From: Nicola Moore
Sent: 06 May 2022 12:02
To: chris barrow
Subject: RE: 16 cardinals drive - NMA

NORTH ELEVATION

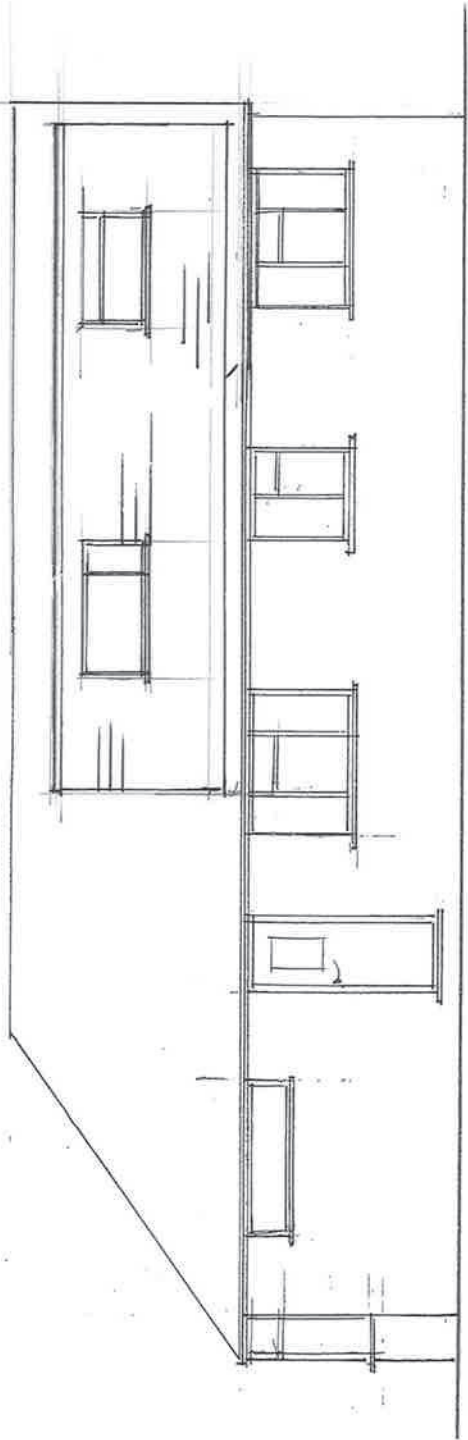
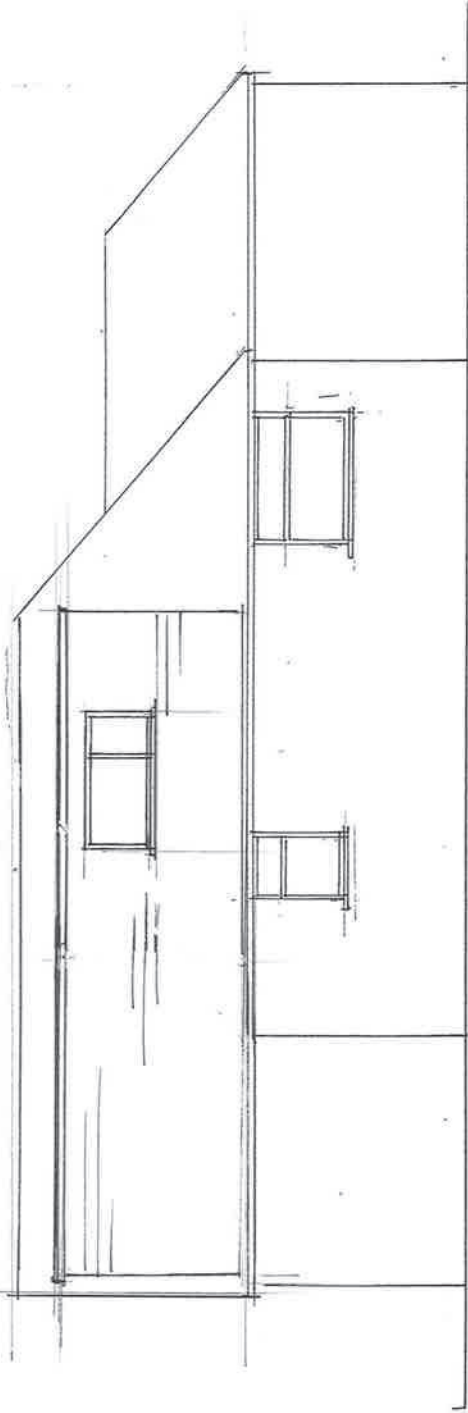
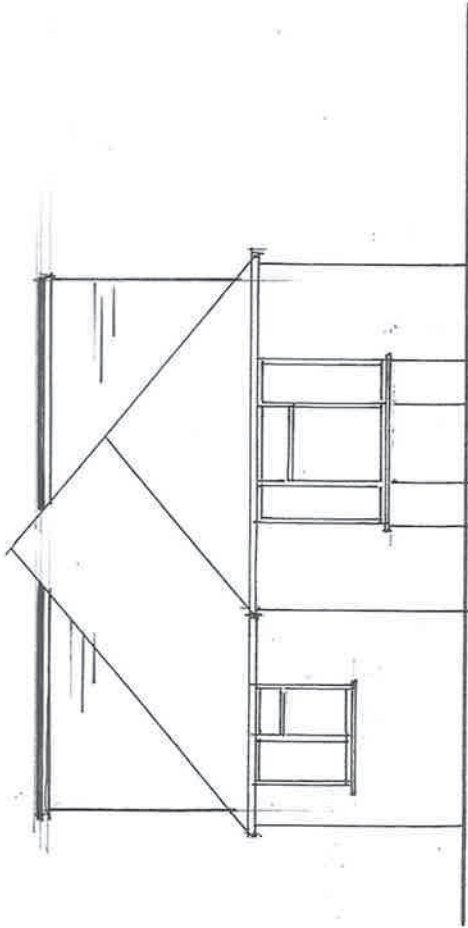
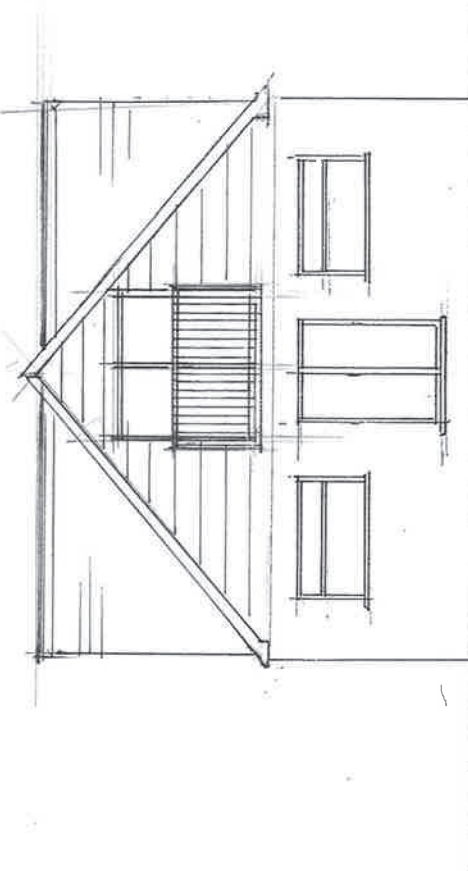
Ensuite window measures 1.10m approx. on the Proposed First Floor Plan , but 1.30m approx. on the Proposed North Elevation.

Please can you check these measurements, amend accordingly and re submit.
